BLANCHARD LETENDRE
ENGINEERING

Our File Reference No: 23-172

SUBJECT:	2ND REVIEW COMMENTS
PROJECT ADDRESS:	1274 MARYGROVE CIRCLE
PERMIT NUMBER:	FILE # D02-02-23-0016
REPORT TYPE:	ENGINEERING BRIEF

SURVEYOR'S REAL PROPERTY REPORT - PART 1
TOPOGRAPHIC SURVEY OF
LOT 206
REGISTERED PLAN 330973
CITY OF OTTAWA

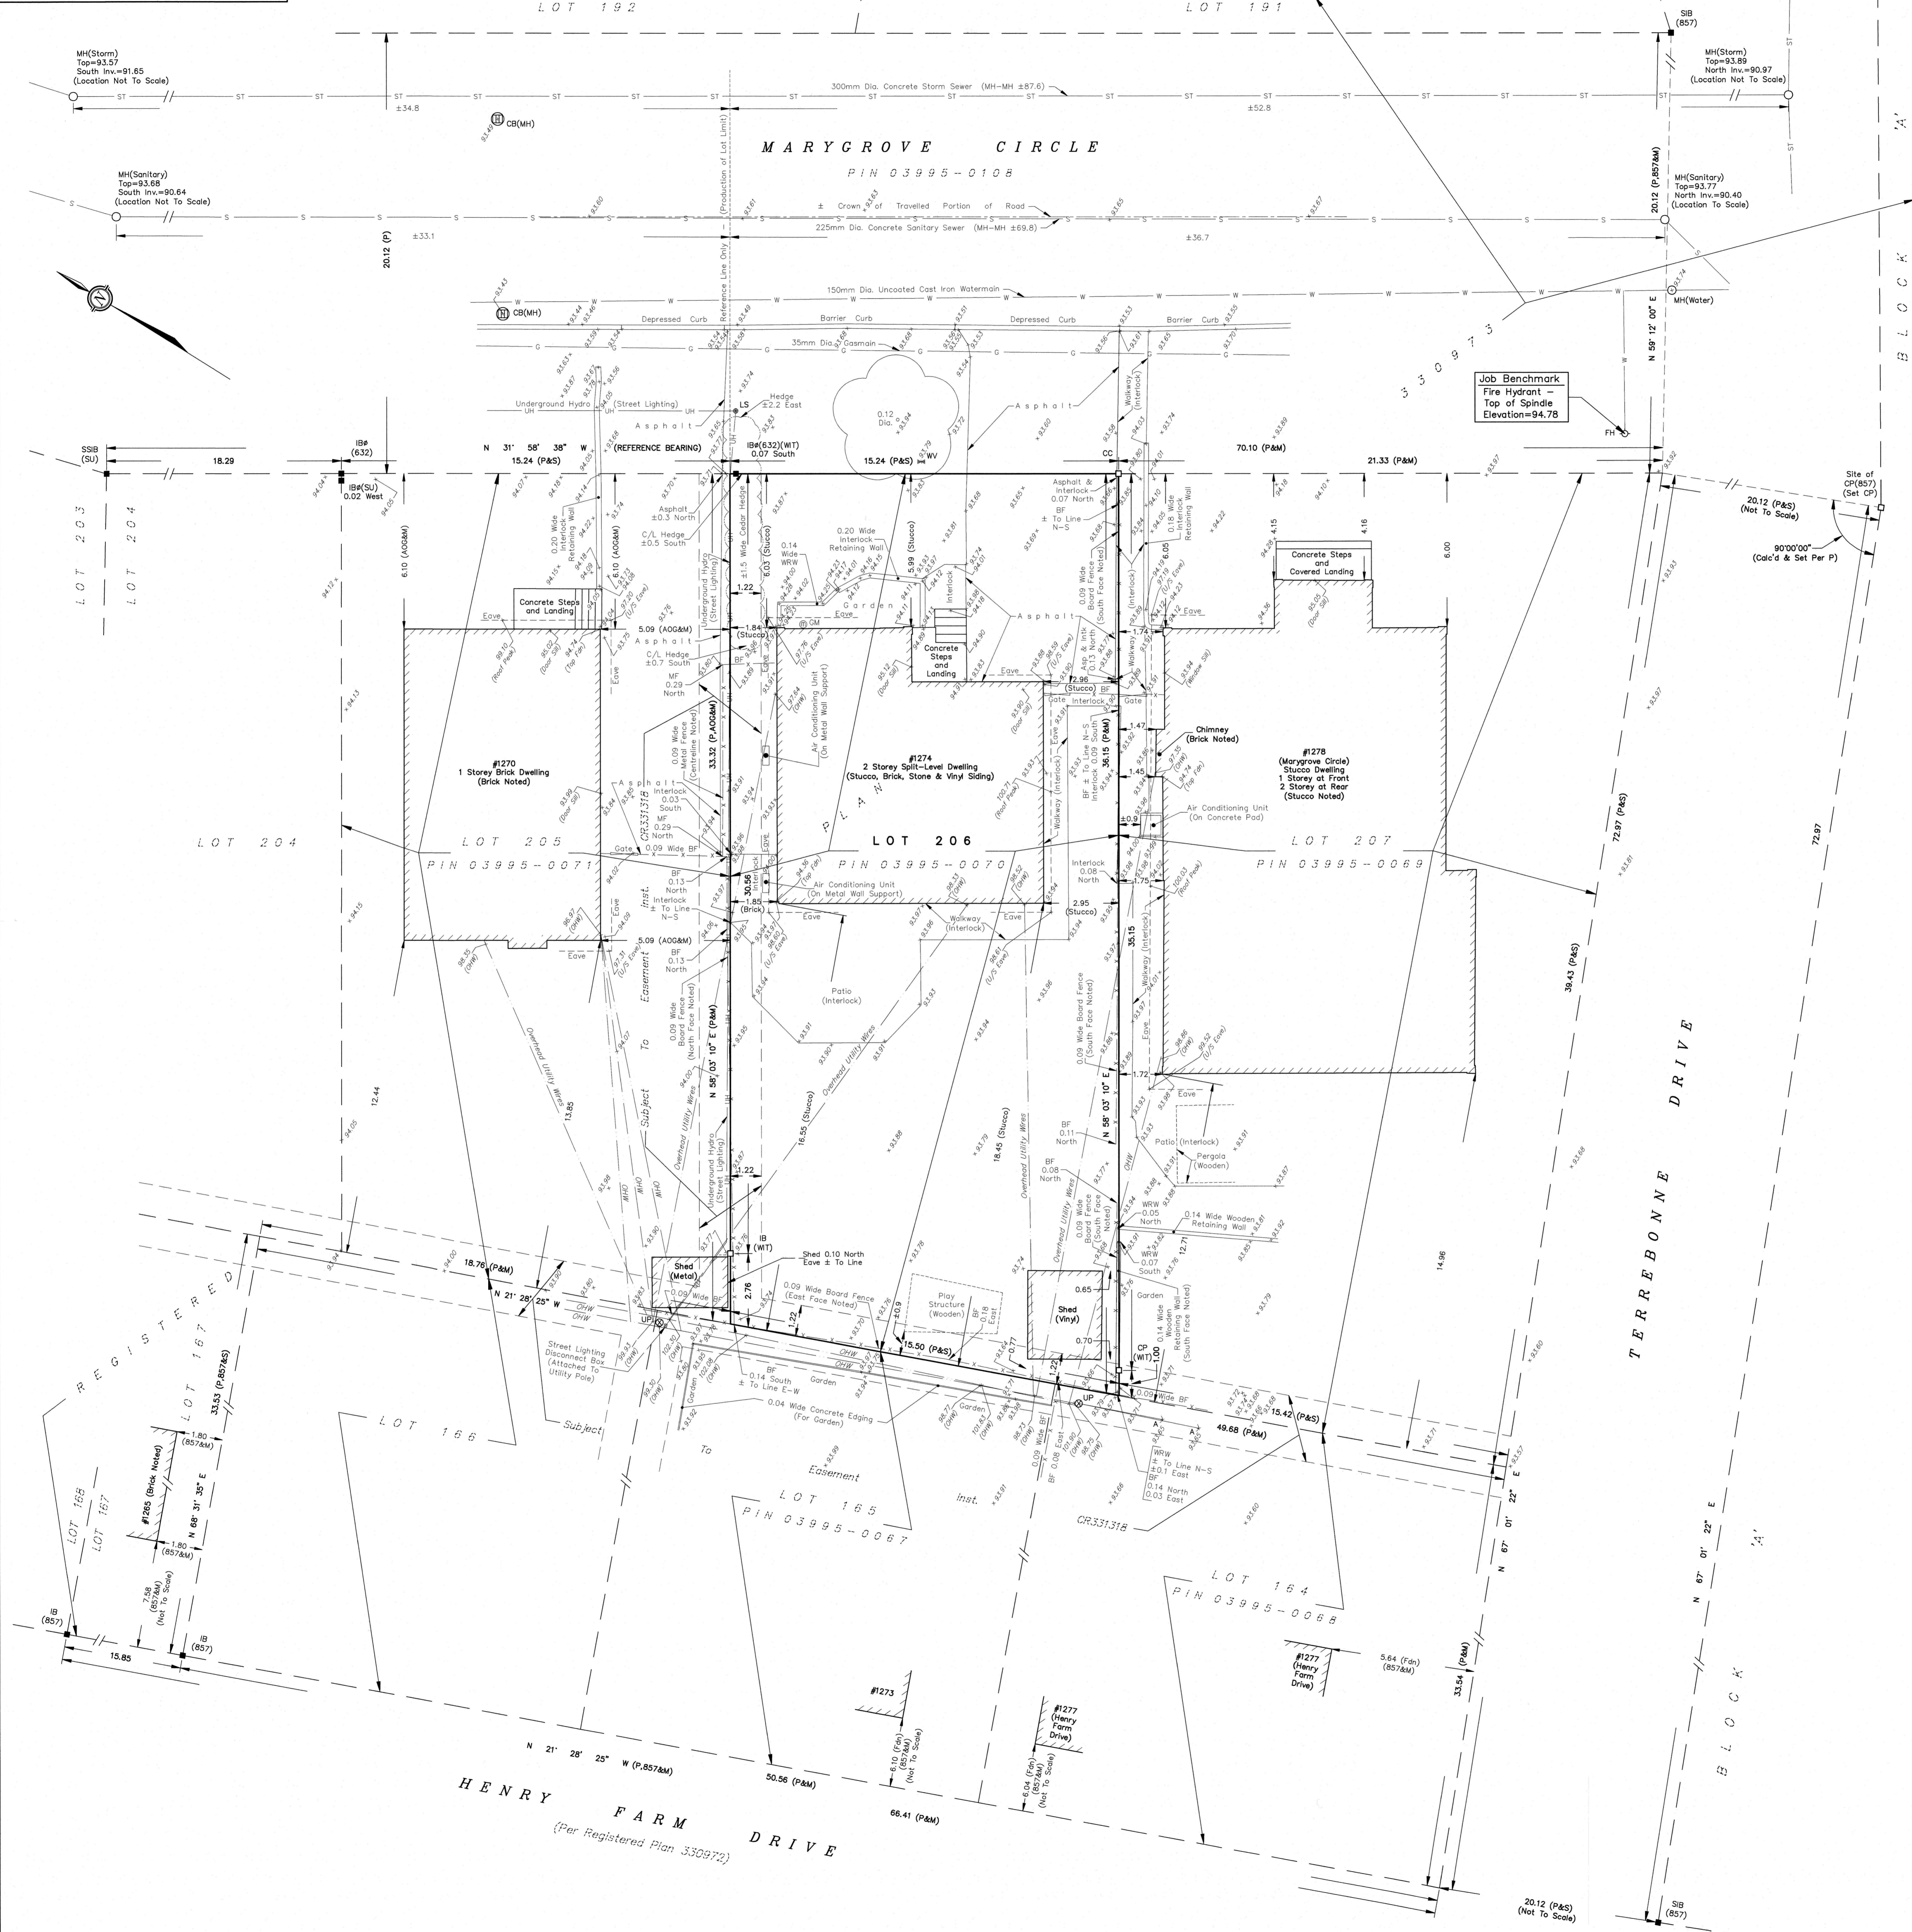
(City 2023): Outstanding. Excess drainage cannot be directed to neighbouring properties. The stormwater management section must include information on the existing site condition and the changes as a result of the proposal along with mitigation measures. Are there existing drainage issues such as ponding/poor grading etc?”

The extent of existing topography available suggests that the existing overland flow for rear drainage occurs in the overhead utility easement. The flow direction is southward.

LOT 206 REGISTERED PLAN 330973 CITY OF OTTAWA (#1274 Marygrove Circle)
GRADE AND SERVICES PLAN

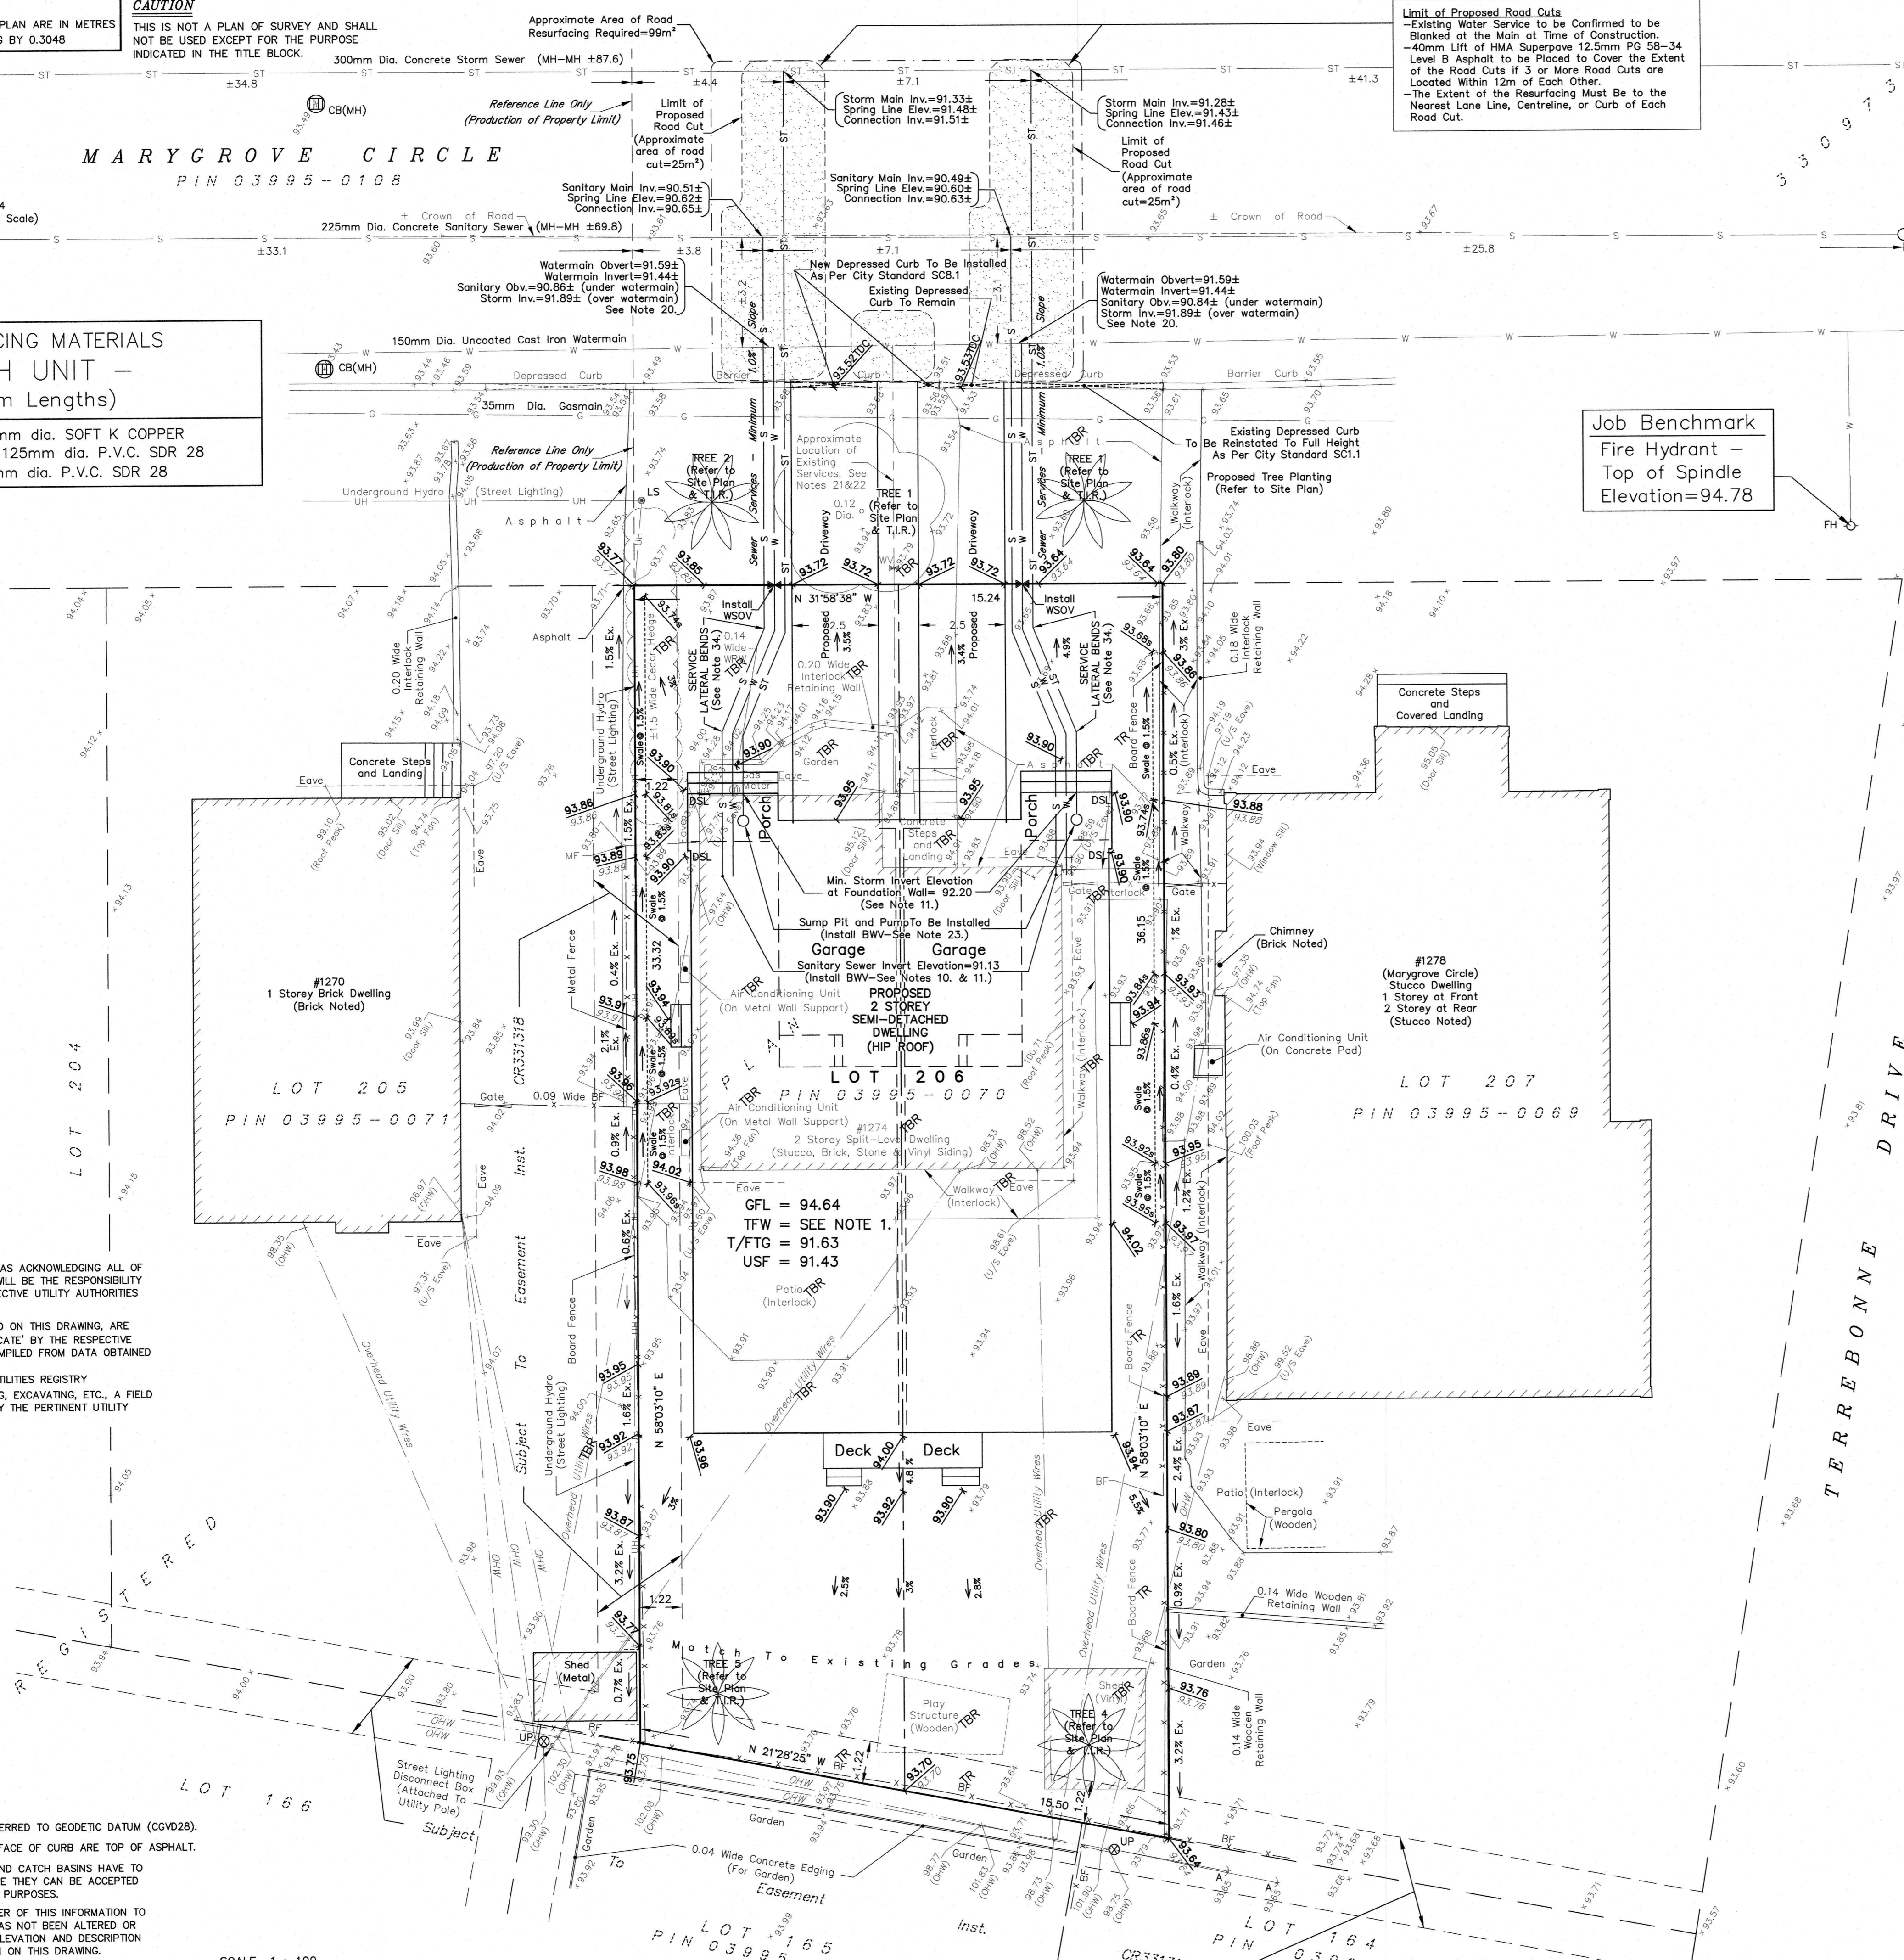
“1.7. The section should discuss the increase in imperviousness. The drainage conveyance methods. How impact to neighbouring properties would be reduced (i.e. roof drains only drain to the street/etc). A drainage sub-catchment plan is helpful.

(LBE Jul 2023): The report has been revised to make general statements on the proposed change in imperviousness, how it is proposed to be graded and drained (by others) A drainage sub-catchment plan is not available, however the grading plan is, from which this information can be inferred.

The proposed conditions are based on the Grade and Services Plan, prepared by Fairhall, Moffatt & Woodland Limited (Job # AC28000, dated January 25, 2023).

The proposed development features a pair of semi-detached residential dwellings with sloped roofs. The proposed grading scheme by FM&W features split lot drainage, with a highpoint that has been moved slightly further back within the property. The following table identifies the two drainage area characteristics, where A201 is the front yard and A202 is the rear yard.

The proposed development will result in a small net decrease in uncontrolled run-off to the rear property lines as a result of this development, while there will be a small net increase in uncontrolled run-off to the City ROW.

The uncontrolled area to the rear maintains a typical assumed weighted run-off coefficient of C=0.5 for infill development. This is not anticipated to have any impacts to downstream infrastructure.

No additional mitigation measures are proposed as part of this development at this time.
